Re: Planning Reference Number 324113

Project Name: Cashla Peaker Power Plant Athenry

Date: 20th April 2026

Purpose		PLANNING			
Title		SITE ACCESS SIGHTLINES			
Original Scale	Design/Drawn	Checked	Authorised		
SHOWN at A1	PS	ND	AJB		
Date	Date	Date	Date		
01.12.25	01.12.25	01.12.25	01.12.25		
Status	Drawing Number	Rev			
A2	PEK3-ATK-ZZ-01-DR-CE-901200	0

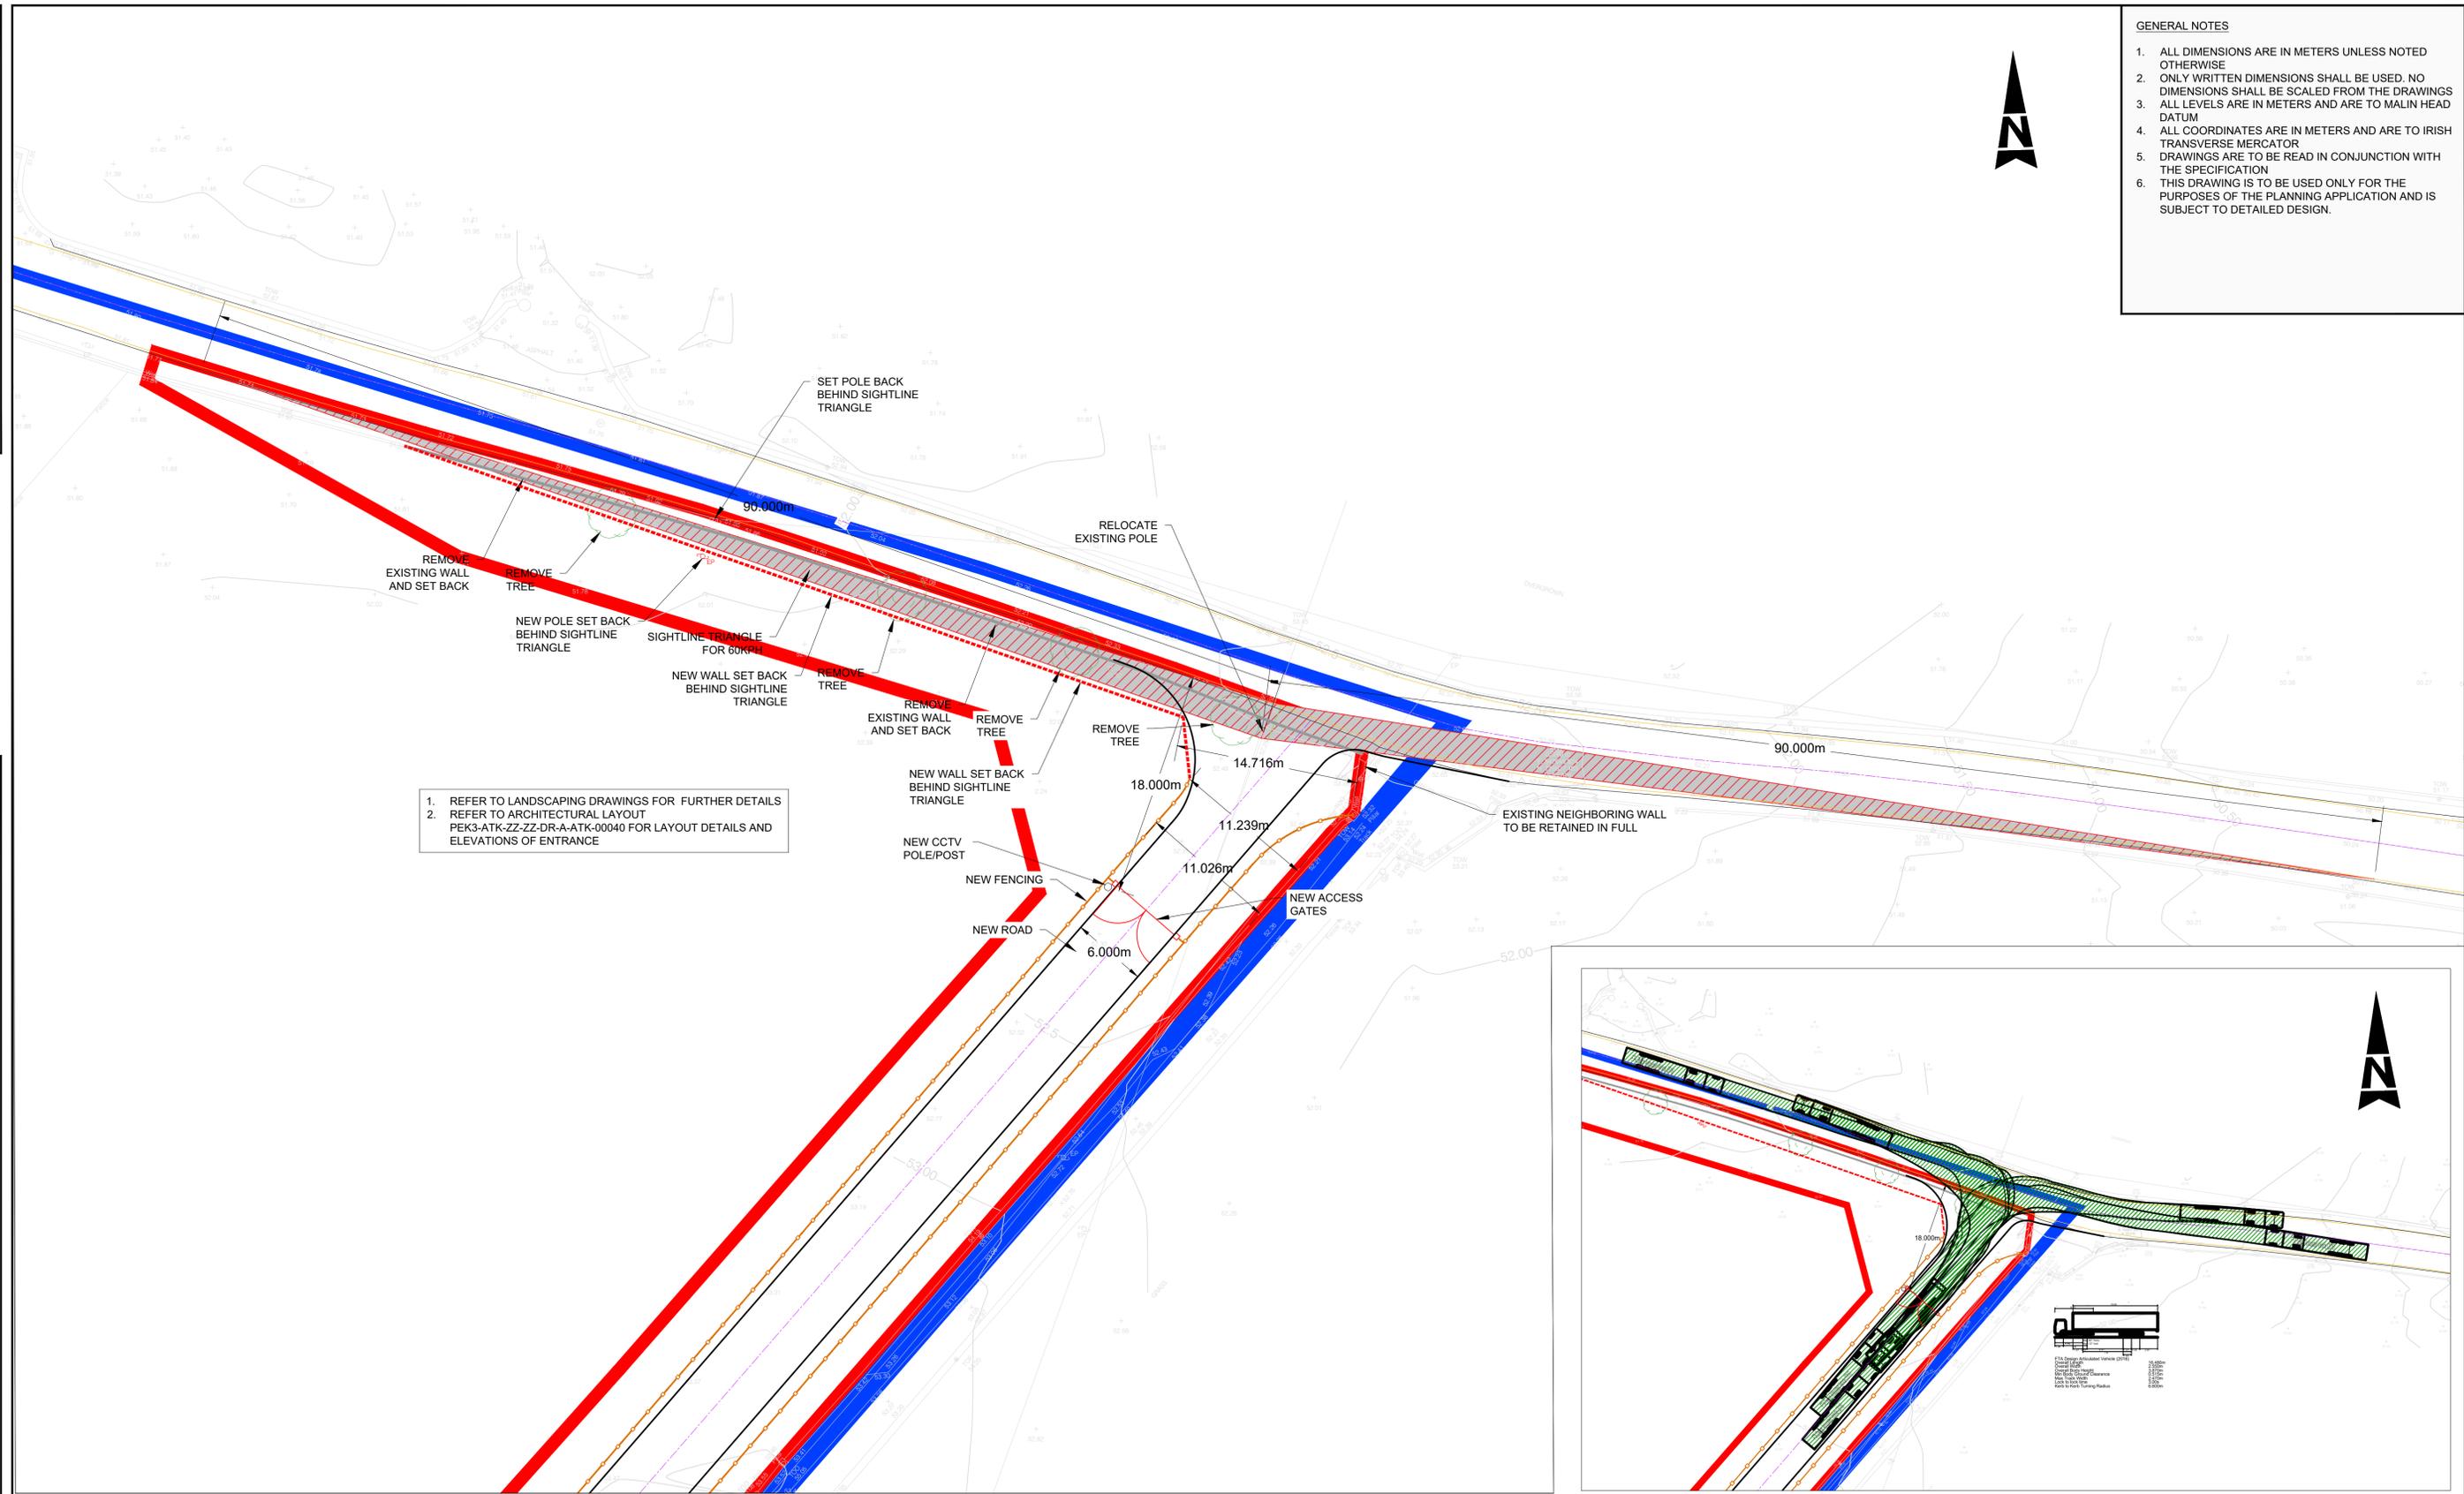
The placement of the proposed site entrance on the L3103 raises severe safety concerns due to the inherently hazardous nature of this specific stretch of road. The carriageway is critically narrow, struggling to safely accommodate two passing Heavy Goods Vehicles (HGVs), and completely lacks a hard shoulder to allow for any margin of error. Compounding these dangers are the presence of blind dips and corners, which significantly reduce visibility and sightlines for all road users. These critical safety deficiencies create an unacceptable traffic hazard that must be comprehensively addressed.
